Subject: Objection to the Planning Ref 2018/91661

Development to old railway line Heckmondwike 2018/91661

Planning application number 2018/91661

Proposed Planning of building of 76 dwellings on the old railway cutting just off Horton street Heckmondwike.

Section 8

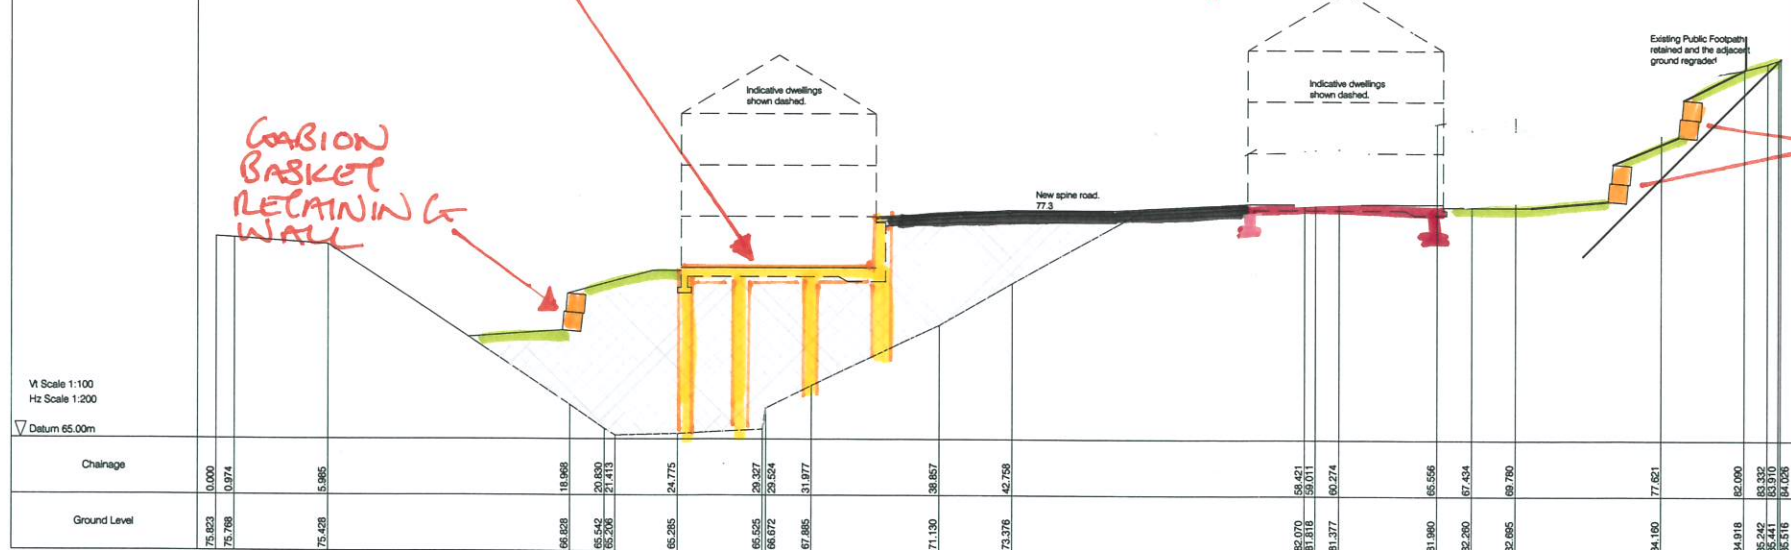
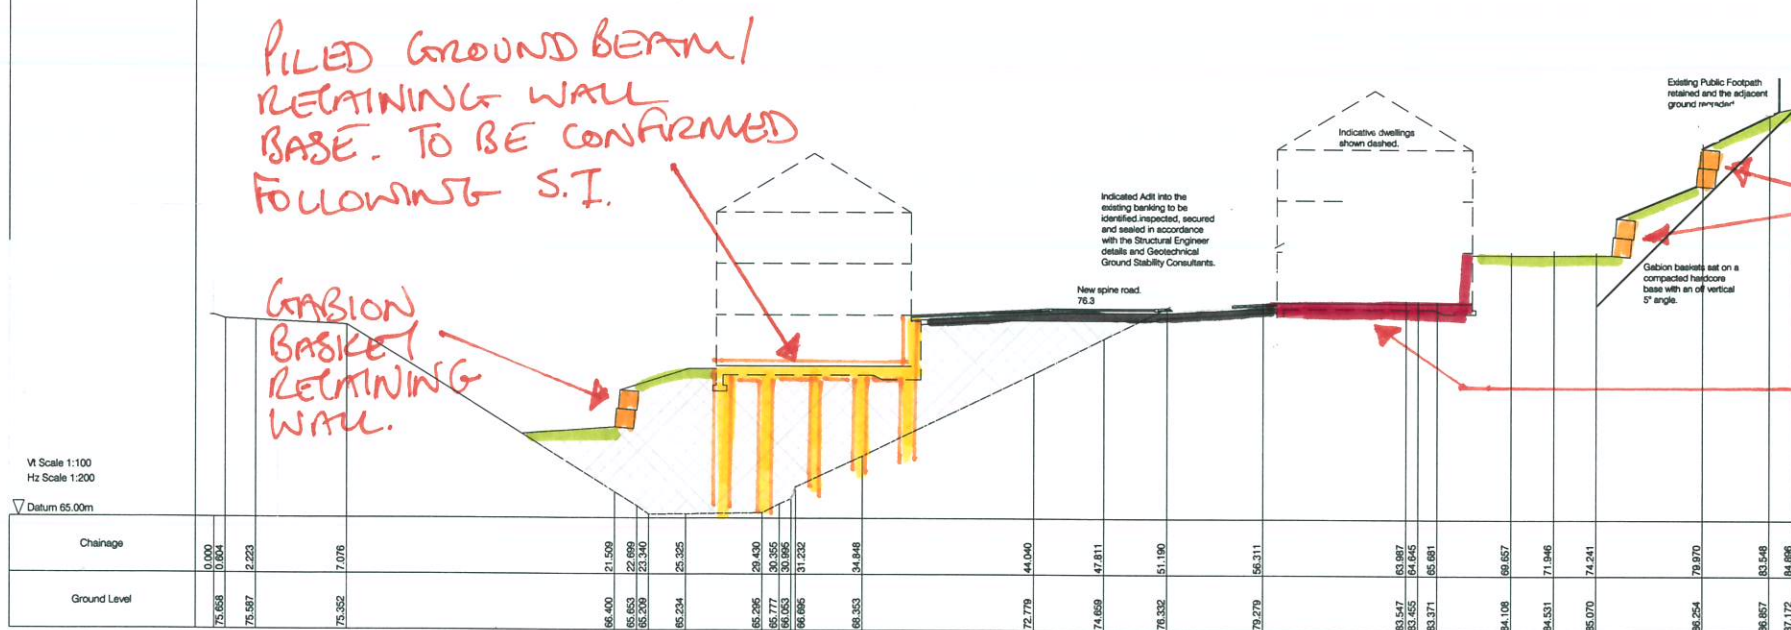
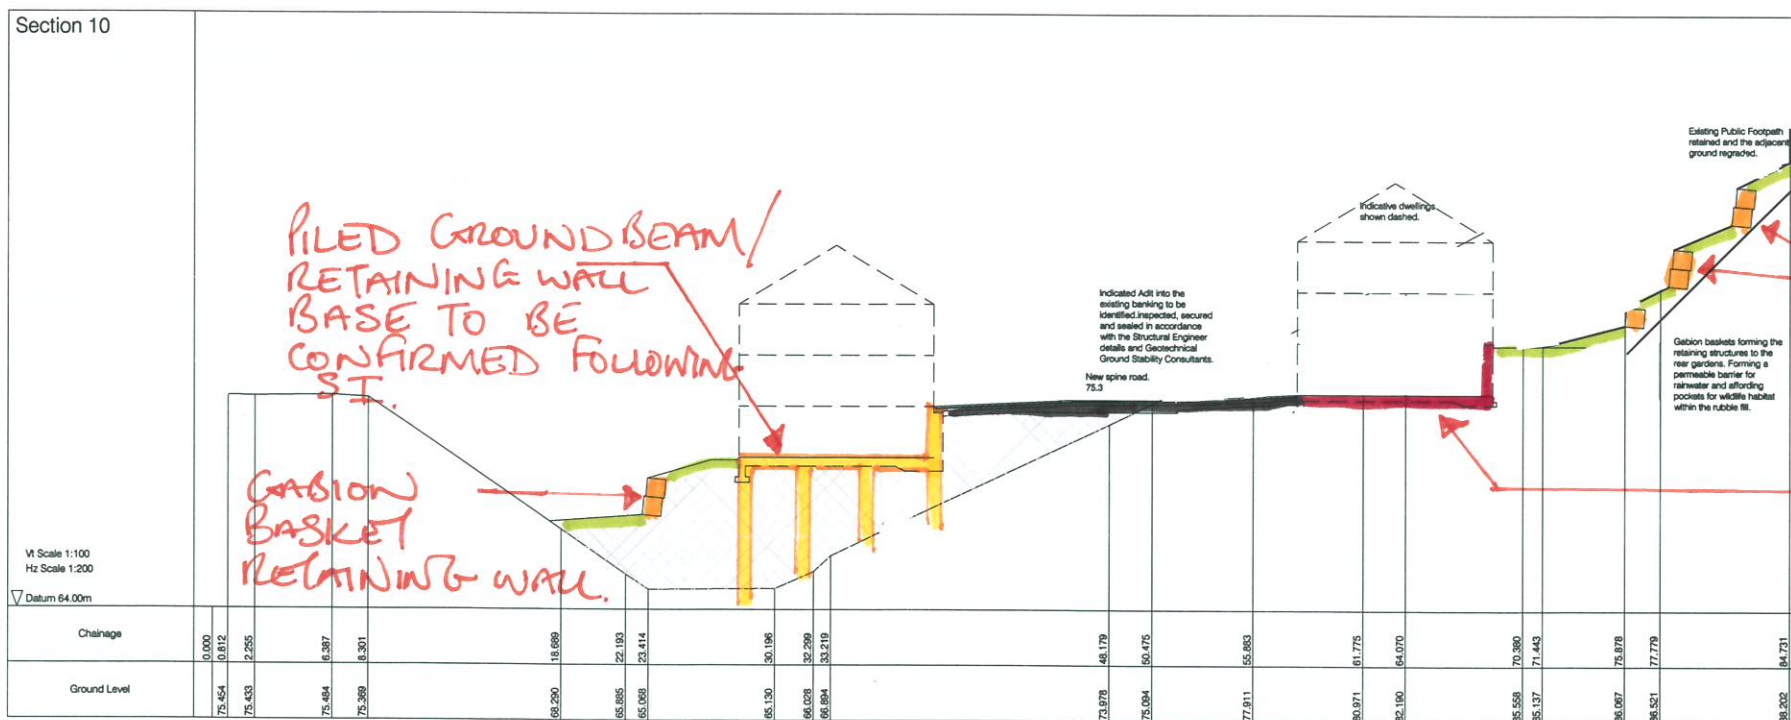
I also understand from the plans that they will be hundreds of piles been driven into the ground, the noise and dust created from this will be absolutely unbearable to local residents plus the health risks are of great concern from the dust and air pollution considering the earth that will need to be moved around and the same again no report on the excising underground mines that are on this site I would also ask you to consider the stability of the land houses and buildings all around to which no reports have been submitted.
